## Hearing Action Points

Application by INRG Solar (Little Crow) Limited for an Order Granting Development Consent for the proposed Little Crow Solar Park project (the Proposed Development)

Actions arising from Issue Specific Hearing 2 held virtually on Tuesday 29 and Wednesday 30 June 2021.

#### Balances and main results

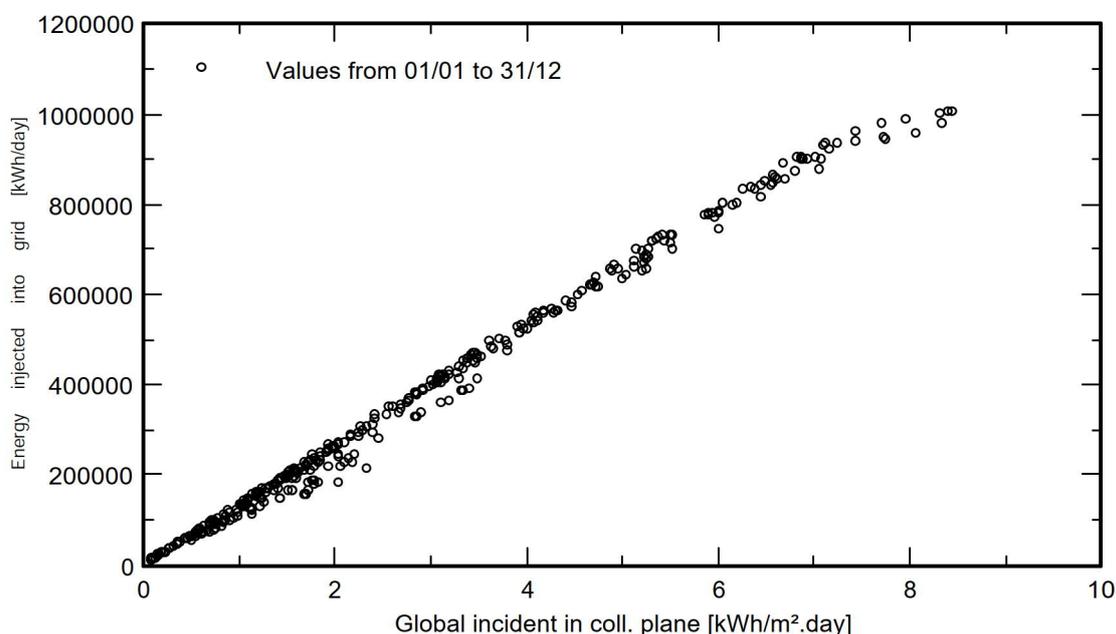
review will have been completed to enable a full written submission to be made.
4	<p>With respect to the:</p> <ul style="list-style-type: none"><li>• Outline Construction Environmental Management Plan [REP3-007];</li><li>• Outline Decommissioning Strategy [REP3-009]; and</li><li>• outline Landscape and Ecological Management Plan [REP3-011]</li></ul> <p>The final versions of these documents to be clearly titled as being Appendices of the Environmental Statement, to reflect the status of these documents when their original versions were first submitted as part of the application documents.</p>	<b>Applicant</b>	7
5	<p>A supplement to or a new version of the Technical Guide [REP1-011] that covers the matters discussed under agenda item 3a) 'solar energy generation technology' and including an arithmetic check for the 'PR' column in the 'Balances and main results' table on the fourth page of Appendix 2 [REP1-011].</p>	<b>Applicant</b>	4
